Your Ref: OWPC24511
Our Ref: R/220/19/PL 16-09-2019
Please ask for:
Richard Castro-Parker

Change of use from Class A2 (financial & professional services) to Class A1 (retail)
/Class A3 (restaurant & cafe) /A4 (drinking establishment) with alterations to the
shopfront to create an external seating area.

2 Ash Lane Rustington

PLAN OF EXTERNAL SEATING AREA SCALE 1 : 50

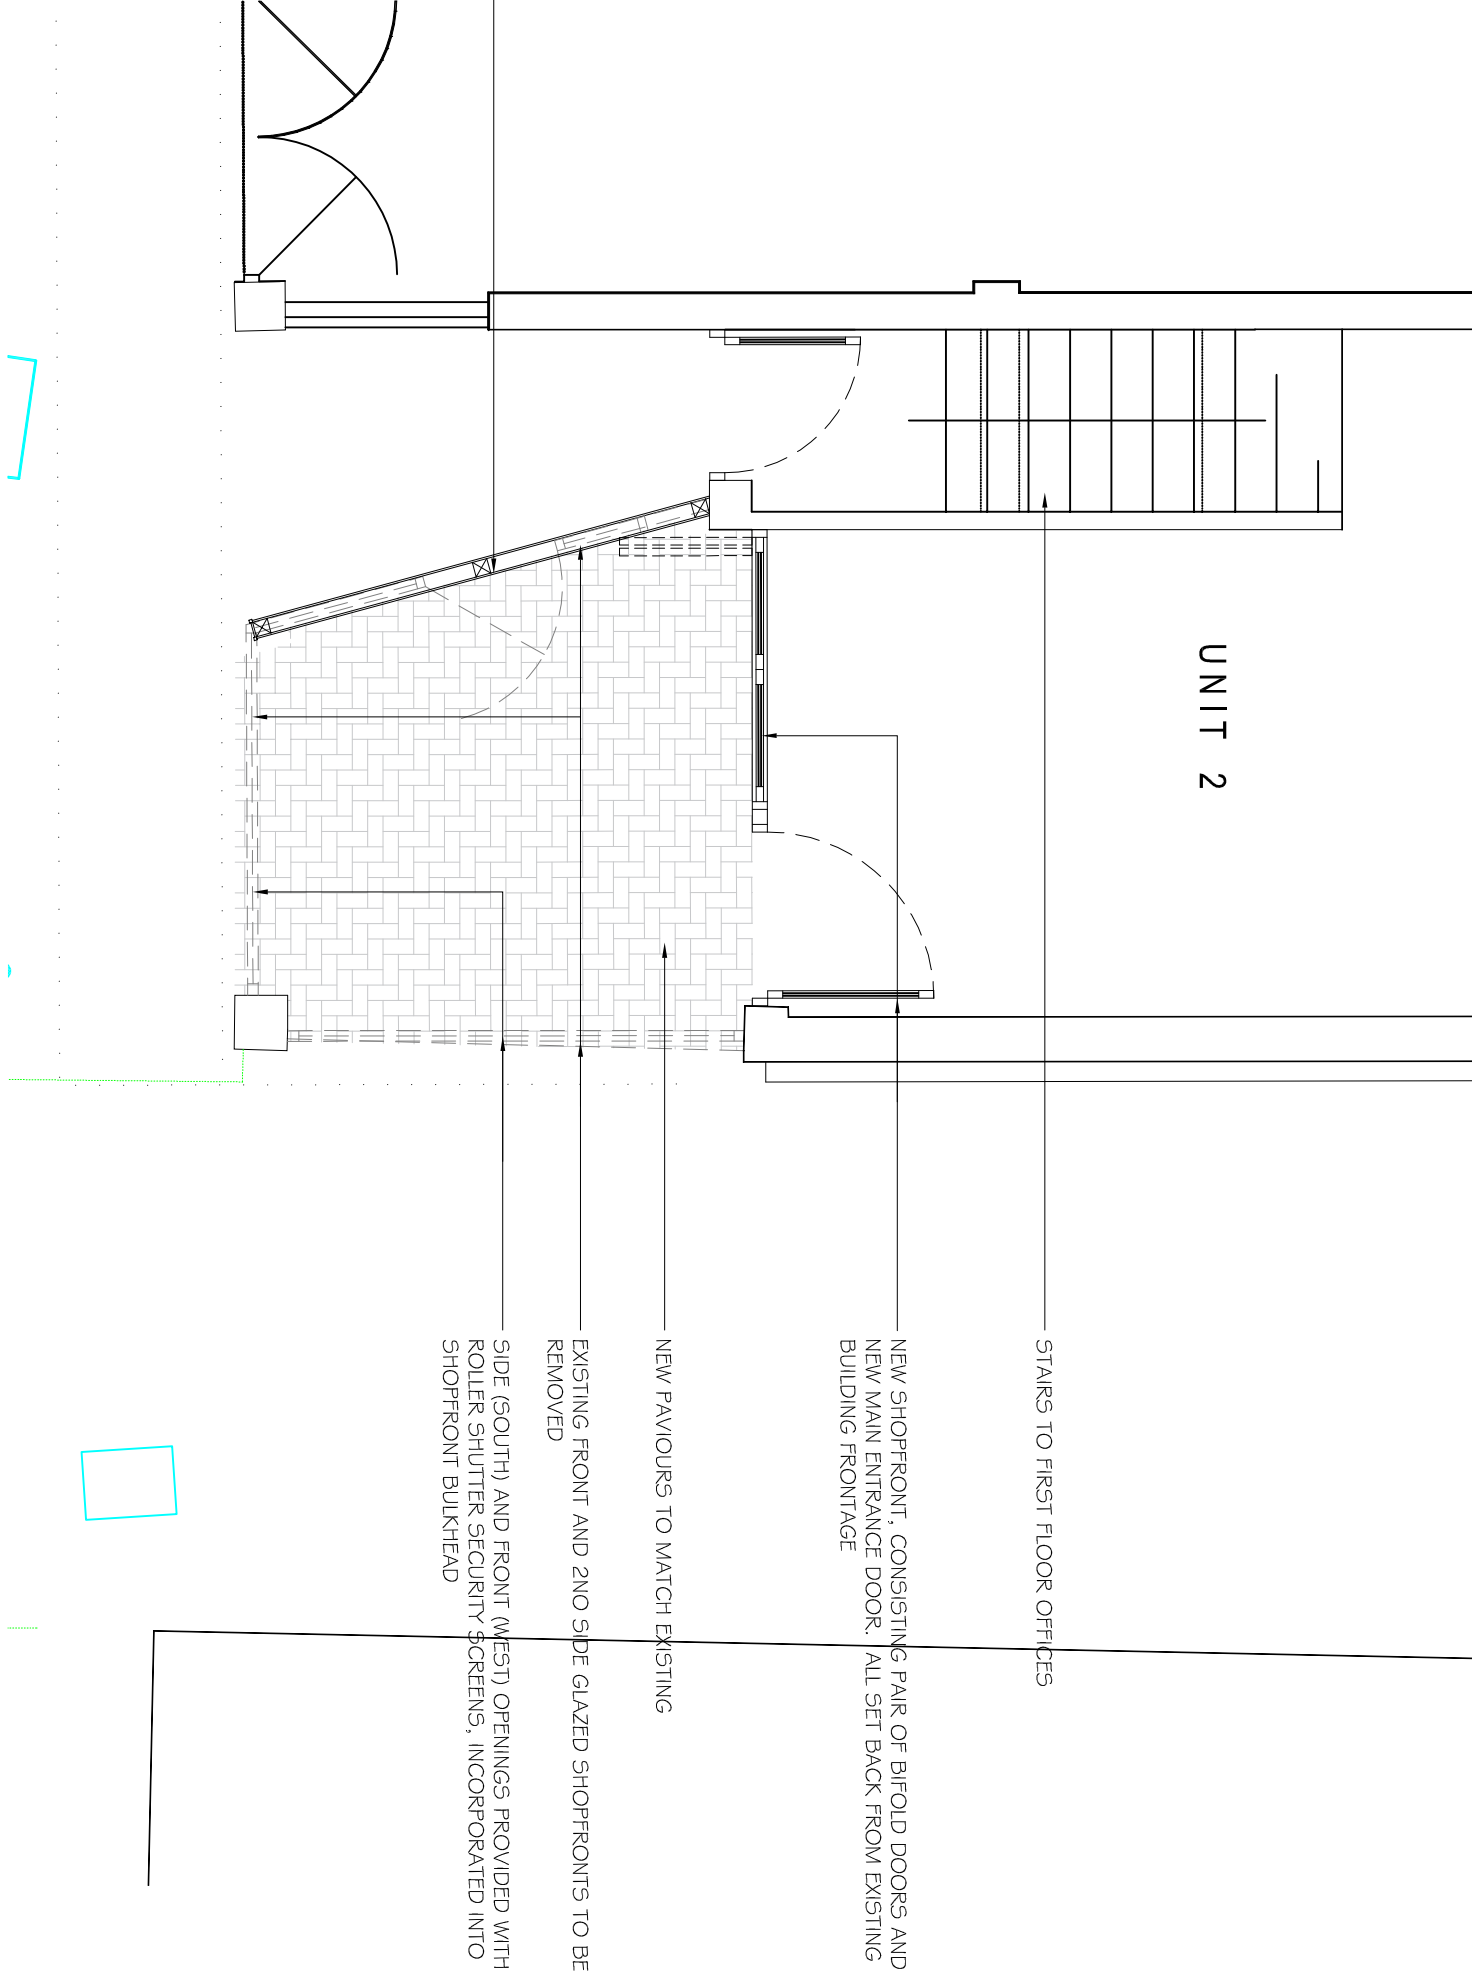
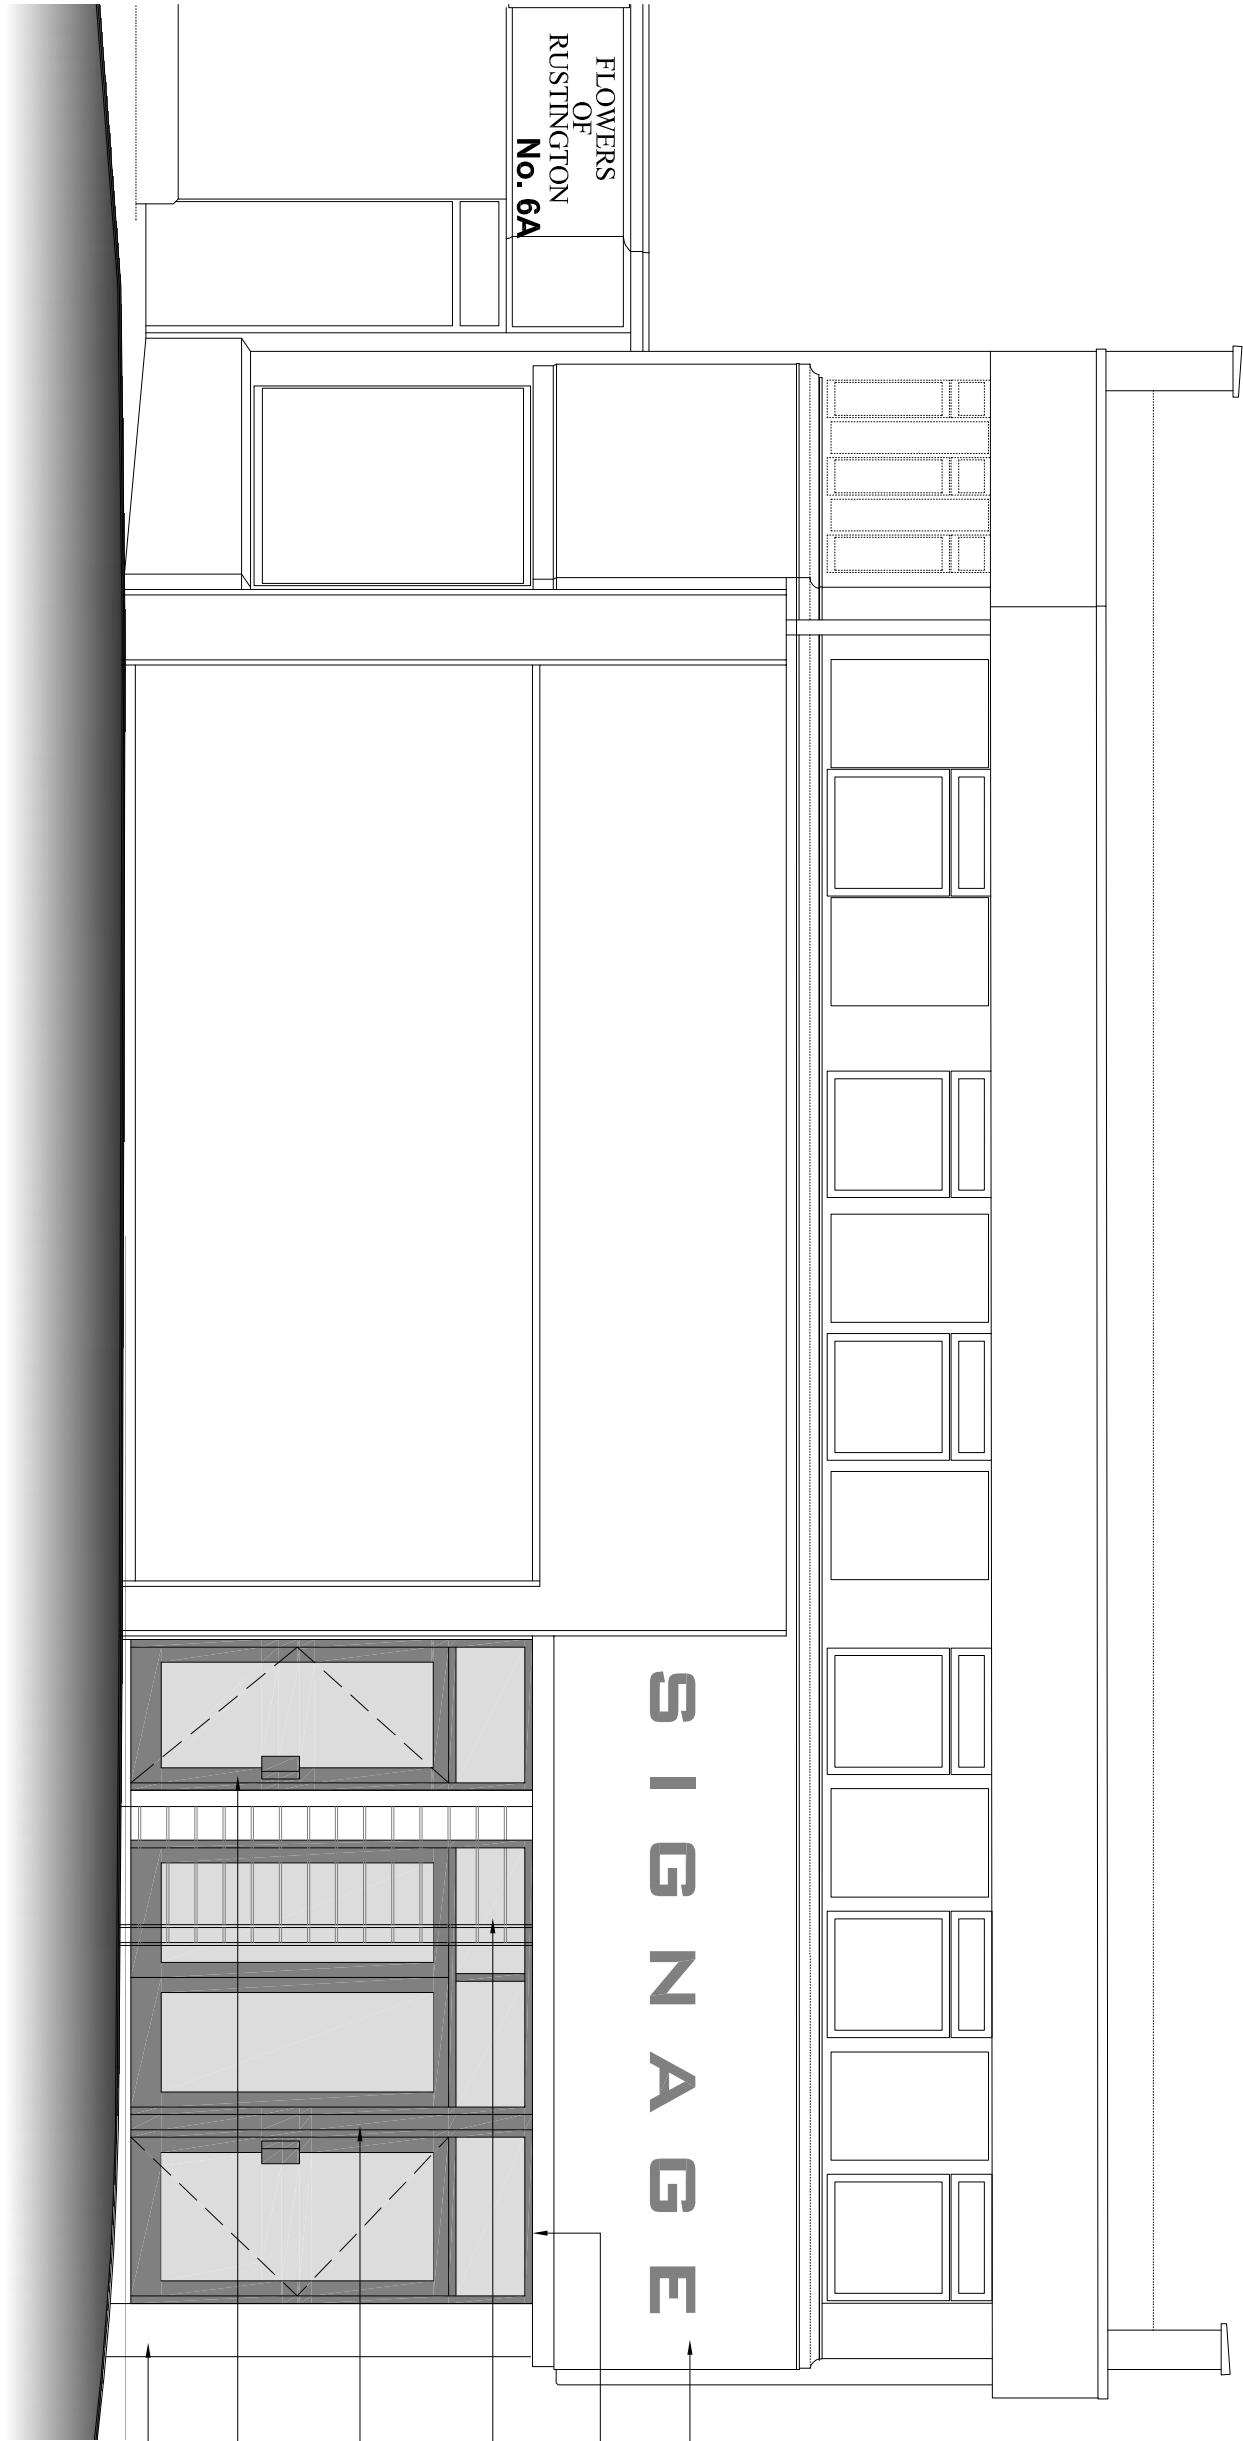
*Our offices are above the premises (incorrectly referred to as a flat in the application). The
pavement seating will obscure and obstruct the entrance to the office.*
